Addendum No. 1

RE: Contract # C204793

Rockingham County (BR-0041, BR-0043)

BRIDGE 78001 OVER US-29 ON SR-2817 AND BRIDGE 780151 OVER US-29 ON US-158.

PROJECT REFERENCE NO.	SHEET NO.
BR-0041	UC-5
DESIGNED BY:	3/27/2023
DRAWN BY:	
CHECKED BY:	
APPROVED BY:	
REVISED:	
UTILITIES ENGINEERING SEC. PHONE: (919) 707-6690 FAX: (919) 250-4151

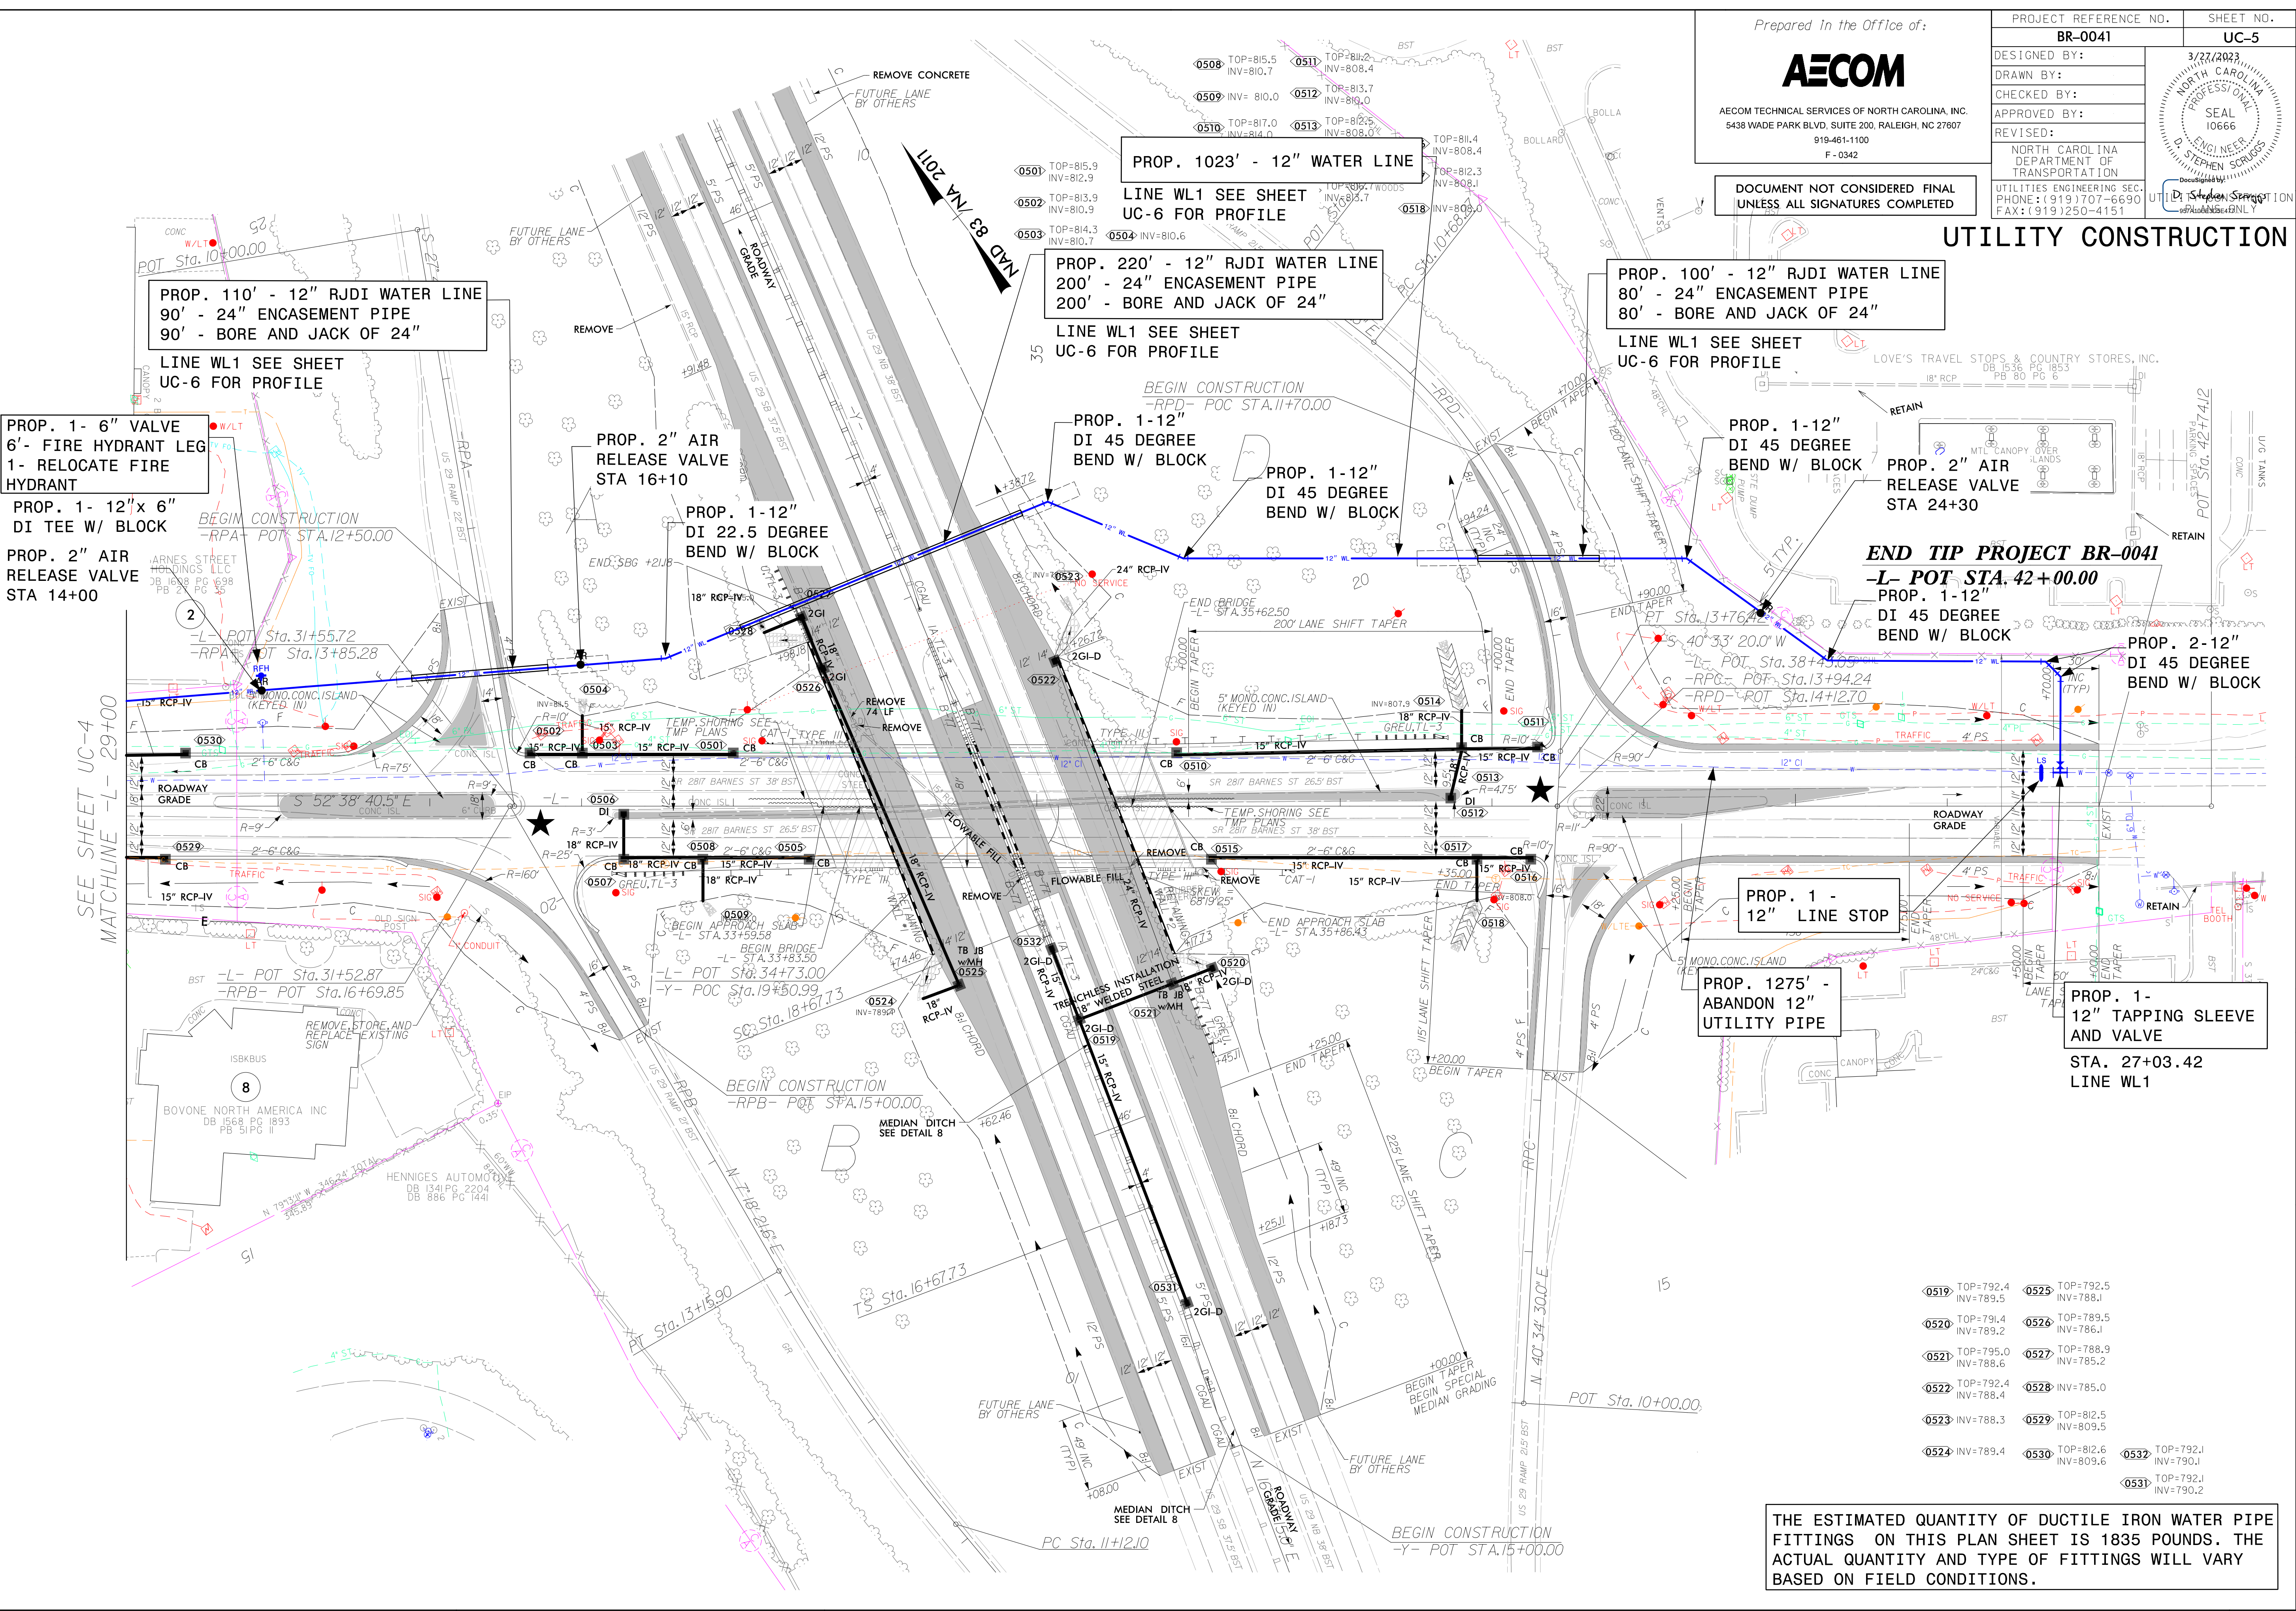
Sheet No.	Revision
UC-5	Revised to remove roadway and drainage notes that do not apply to the utility construction.
UC-6	Revised to call for a 12-inch vertical separation between the water main WL1 and existing gas mains.
